2000-1 Addison Circle

Roundabout Design & Operational Review (Lee  
Engineering) - 2005

**ADDISON CIRCLE  
DESIGN, OPERATIONS, AND SAFETY REVIEW**

**Performed For:**  
Town of Addison  
16801 Westgrove Drive  
Addison, TX 75001

GEOMETRIC PLAN
ROUNDBOUT - QUORUM DR. & MILDRED ST.
ADDISON CIRCLE
PHASE I PUBLIC INFRASTRUCTURE
TOWN OF ADDISON, TEXAS

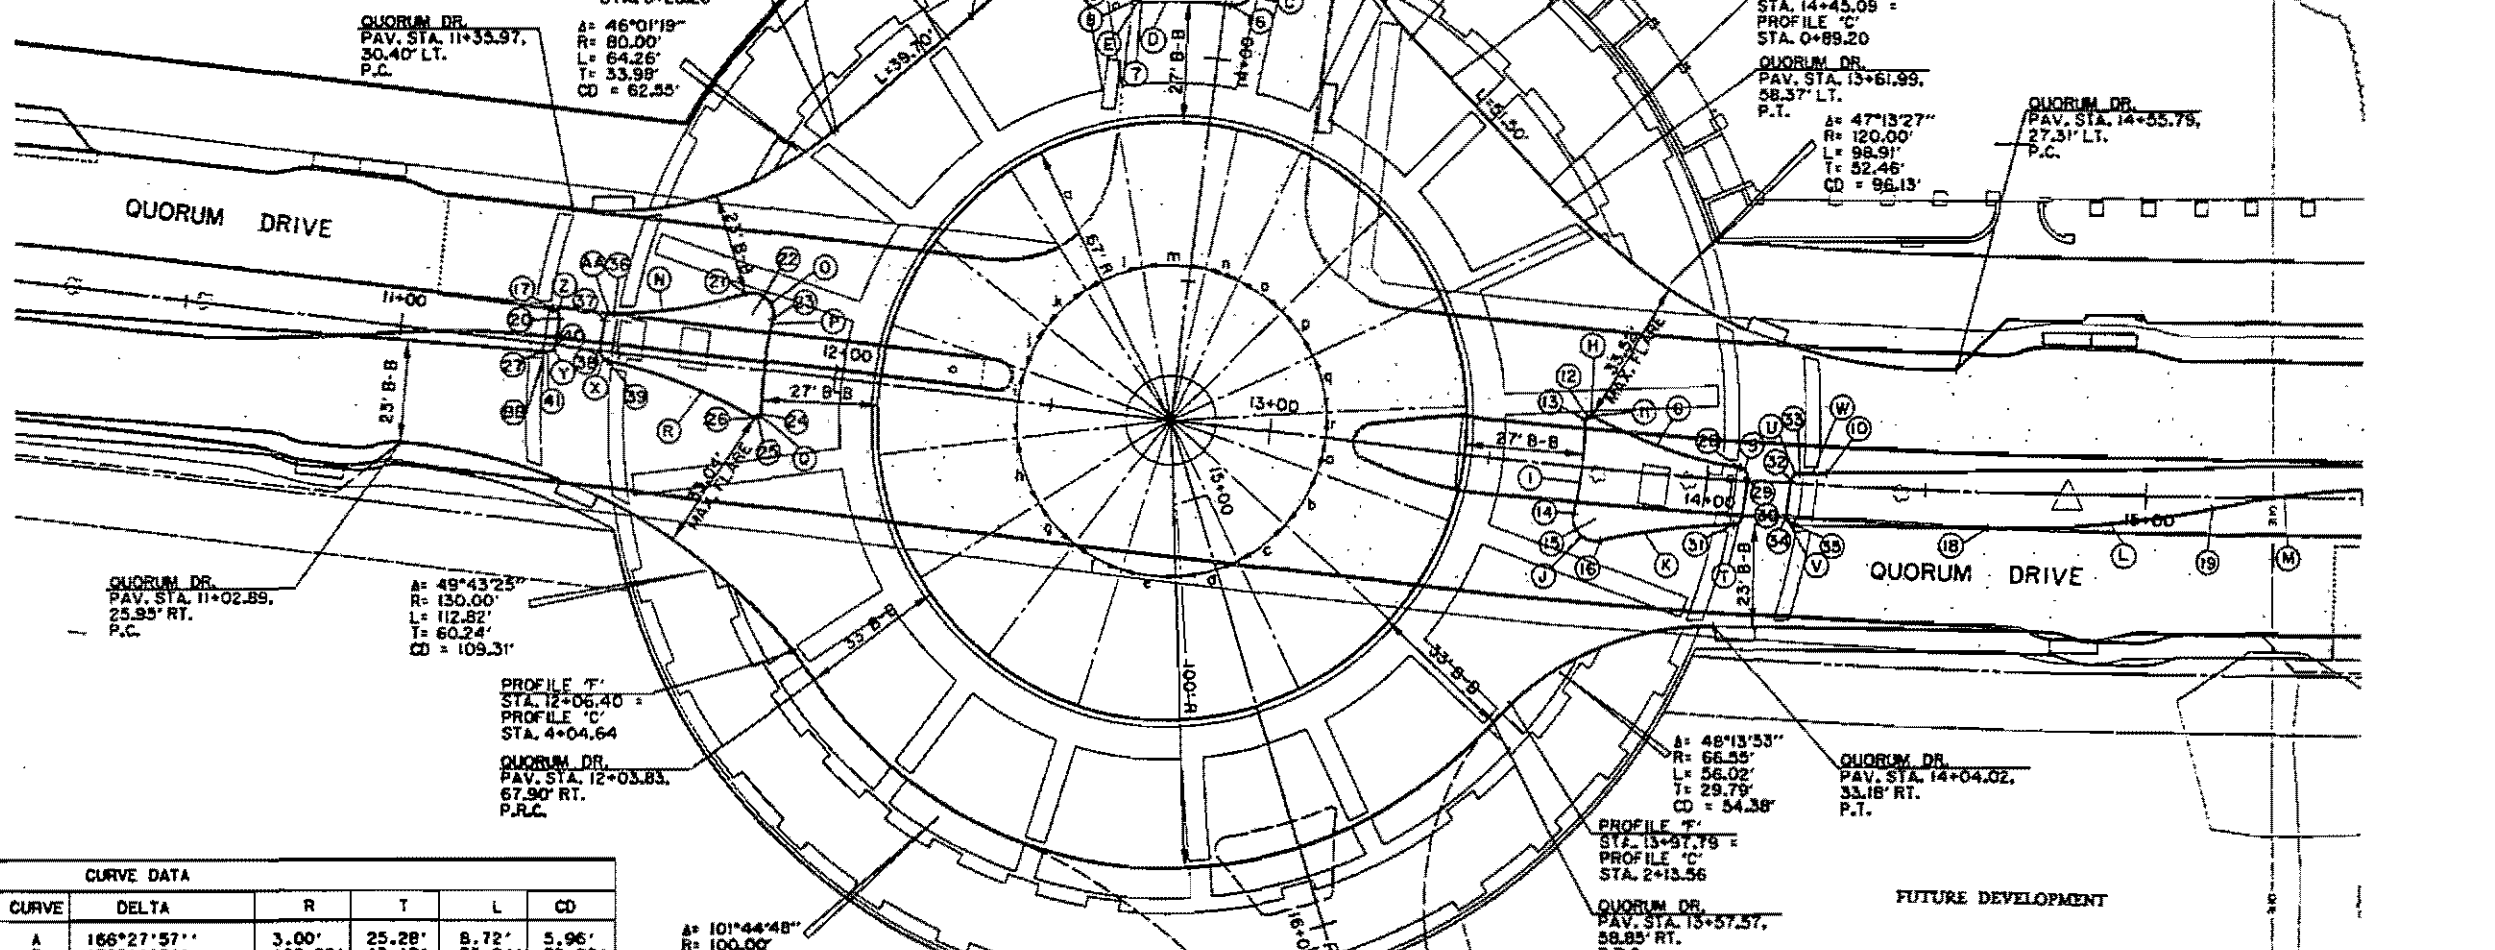
At the Addison Circle roundabout, the northbound and southbound approaches are striped for three-lane entries with widths of approximately 33 feet. However, the width of the circulatory roadway is approximately 27 feet at the splitter islands, thus only wide enough for two lanes. Field observations revealed that the majority of drivers are familiar with the roundabout and choose an entry-lane based on their desired turning movement. Drivers making through or left-turn movements generally use the left-hand entry lane, and

drivers making right-turn movements choose the right-hand lane. Between the northbound entry and eastbound exit, and again between the southbound entry and westbound exit, there is adequate circulatory roadway width for three cars to travel abreast of each other. In the rare event of a three vehicle entry, if the rightmost vehicle intends to proceed through or left, a conflict develops when the vehicles reach the next splitter island and circulatory roadway width can no longer sustain three vehicles abreast. Thus, the roundabout effectively operates as a double-lane roundabout. The three lane entry does not significantly increase the capacity of the Addison Circle roundabout, and due to the inconsistency between the number of entry lanes and circulatory lanes, may increase the likelihood of minor sideswipe crashes within the roundabout.

At the Addison Circle roundabout, path overlap exists at the northbound and southbound entries due to the three-lane entries. The three-lane entries lead to a two-lane circulatory roadway, resulting in path overlap as vehicles in the right two lanes must compete for the same space within the circulatory roadway should both drivers choose to proceed through the roundabout and not take the first right turn available to them. As most drivers are familiar with the roundabouts, vehicles generally use only two entry lanes to avoid these path overlap conflicts. However, as improvements are considered, they should address the path overlap issues and ensure that the entries and exits are designed to promote clear and safe movements for two lanes of traffic through the roundabout geometry.

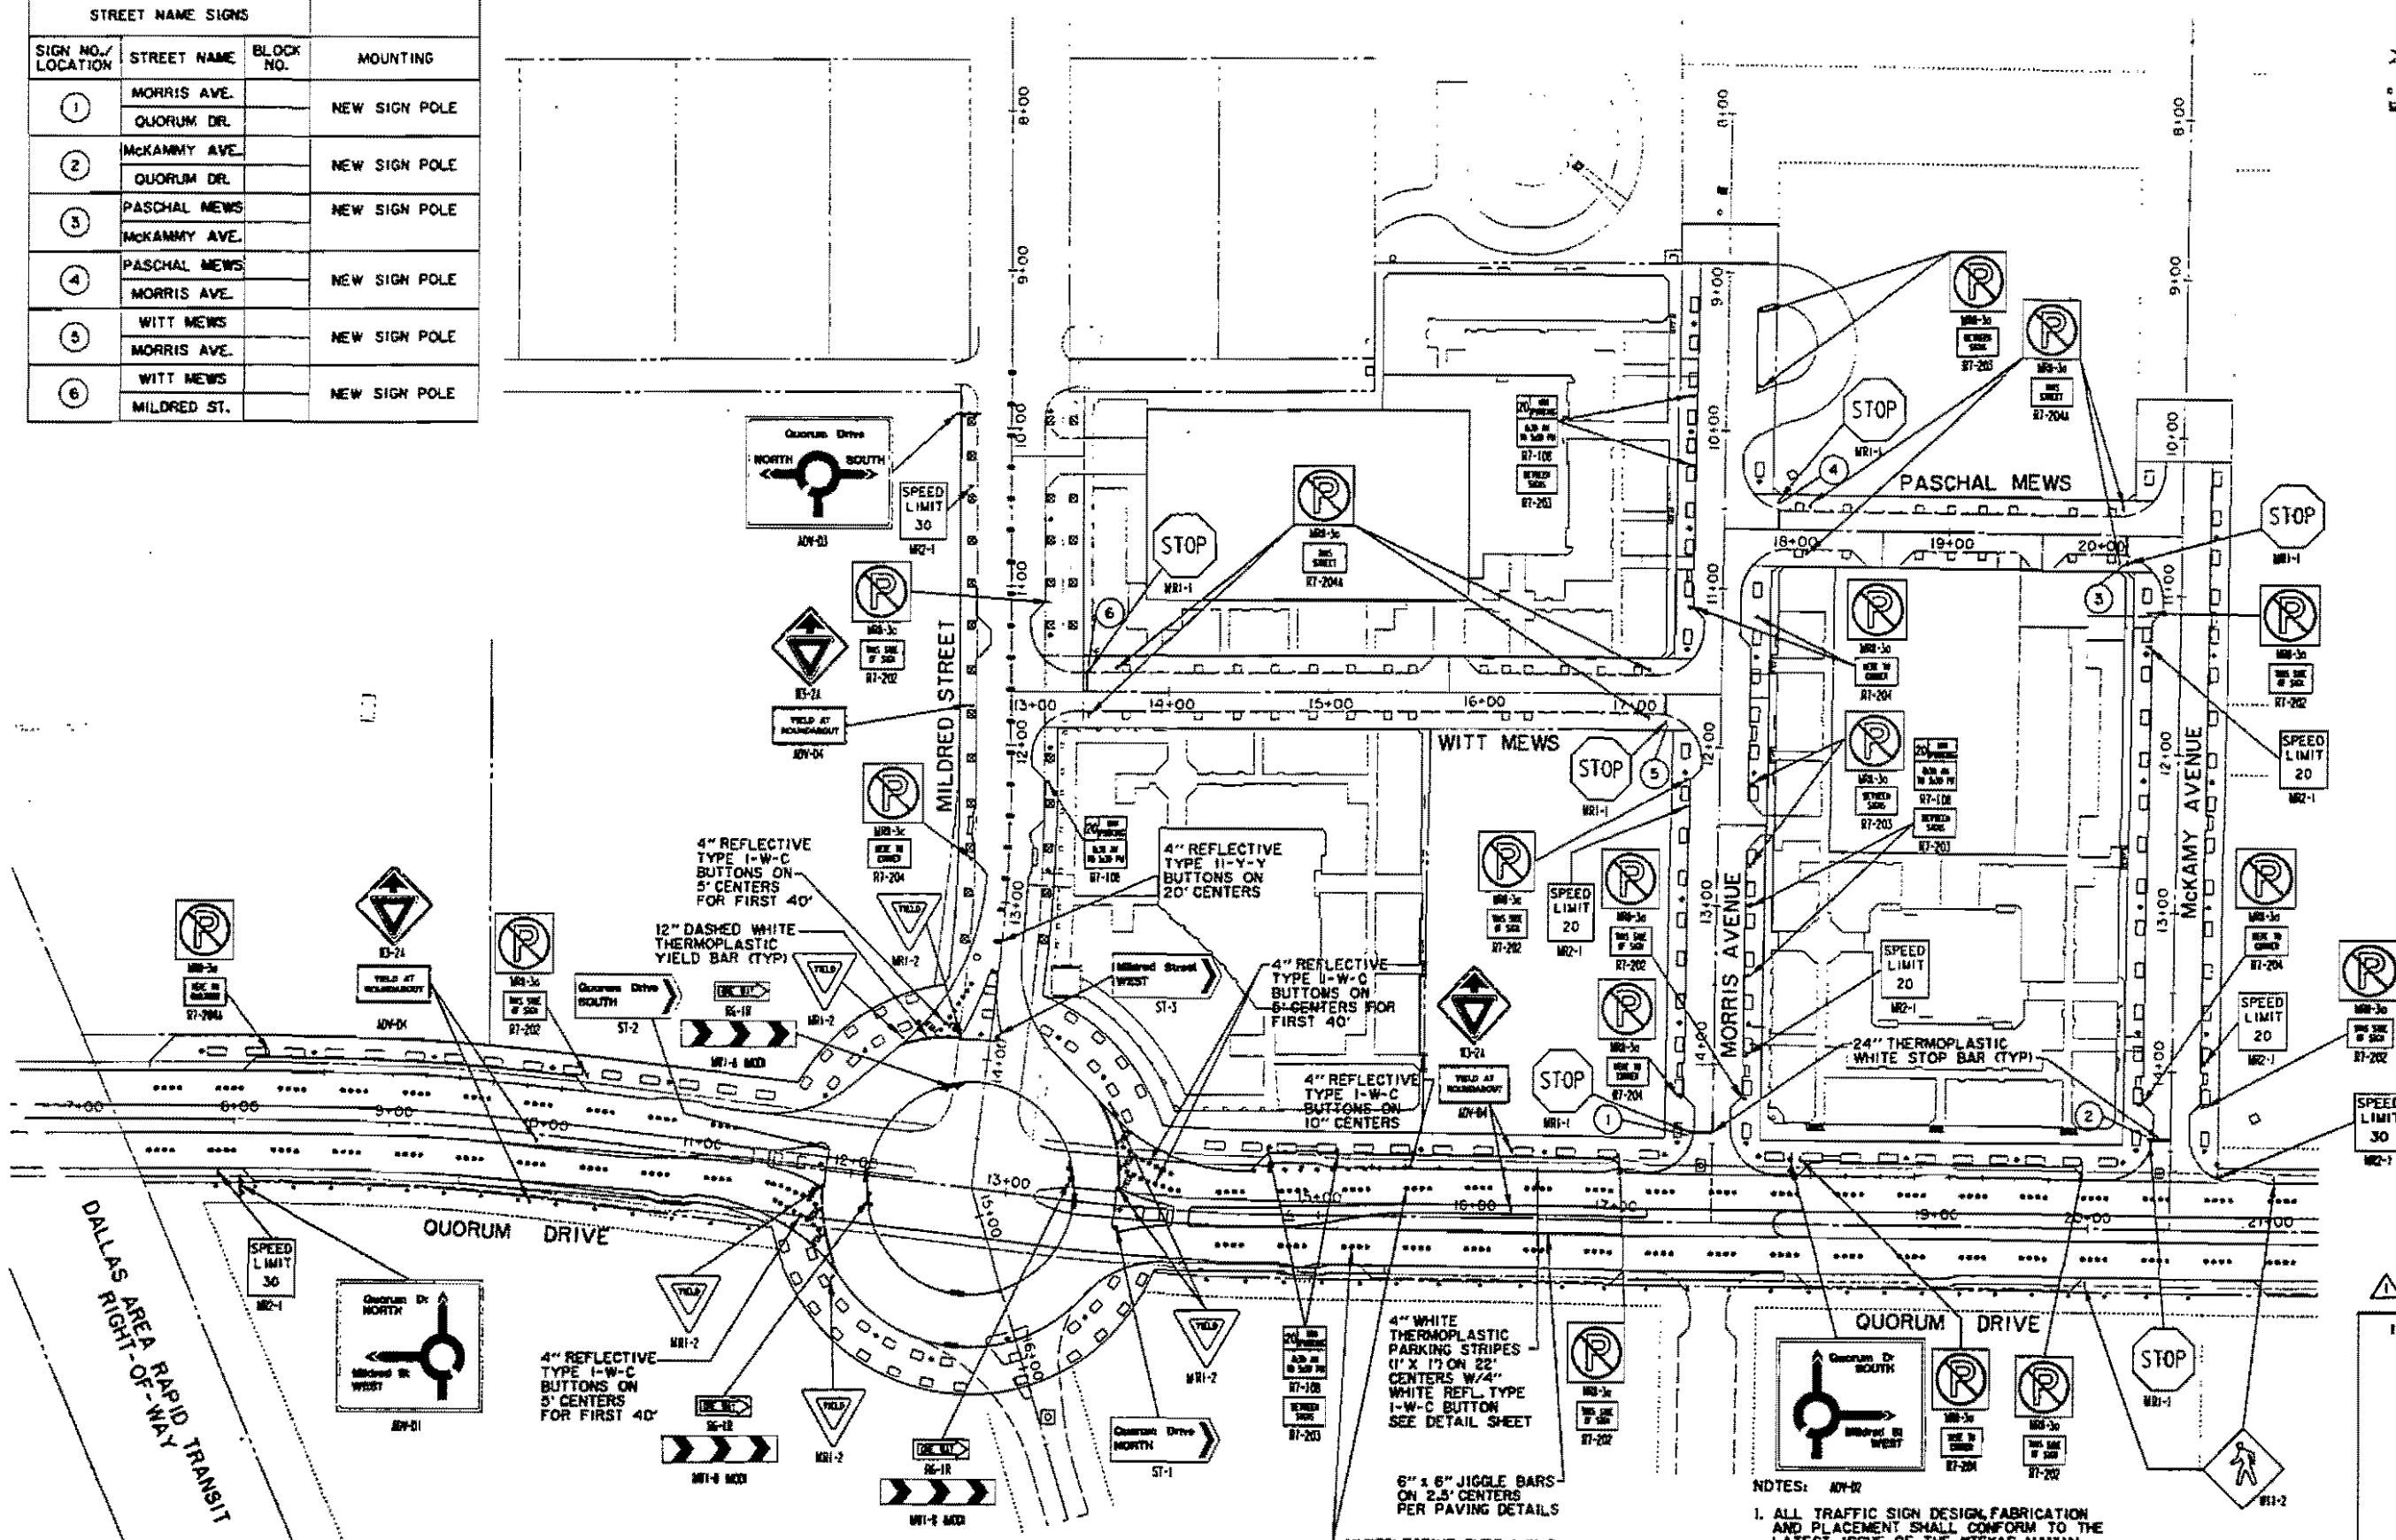
- Pavement markings at the entries are faded and worn, and visibility of these markings is significantly reduced from their original form (*Figure 4*);

- Pavement markings on the northbound and southbound entries divide the roadway into three entering lanes, however most motorists either stay in the outside lanes, or disregard the markings and create two “new” lanes centered on the lane lines;

- Both yield ahead warning signs on the northbound approach and one yield-ahead sign on the southbound approach are obscured by trees. The second yield-ahead sign on the southbound approach will be obscured by uncut tree growth in the coming months (*Figure 5 & Figure 6*);

- The large green roundabout guide sign on the southbound approach is partially obscured by trees (*Figure 7*);
- The large green roundabout guide signs provide no lane use instructions to motorists approaching the roundabout;

- A yield sign on the westbound approach is obscured by tree growth (*Figure 8*);
- No crosswalk warning signs are present to alert drivers to the crosswalks;

- The yield-ahead sign for the eastbound approach has been placed very low on a no parking sign inside temporary fencing and is missing the “Yield at Roundabout” supplemental plaque present on all other approaches (*Figure 9*);

- Pedestrian activity was significant in the area; however, many pedestrians do not use the existing crosswalks present on the roundabout approaches. Landscaping improvements could encourage pedestrians to use the existing crosswalks.
- Many warning and guide signs have been obscured by the growth of foliage in the area. The existing pavement markings on the approaches to the roundabout need to be refurbished.
- The northbound and southbound entry points should be marked as two-lane entries to correspond with motorists' existing usage.
- A lane line within the roundabout that corresponds to the northbound through traffic movement along with modifications to the northbound and southbound approach guide signs with suggested lane usage should mitigate the northbound vehicular conflict point.
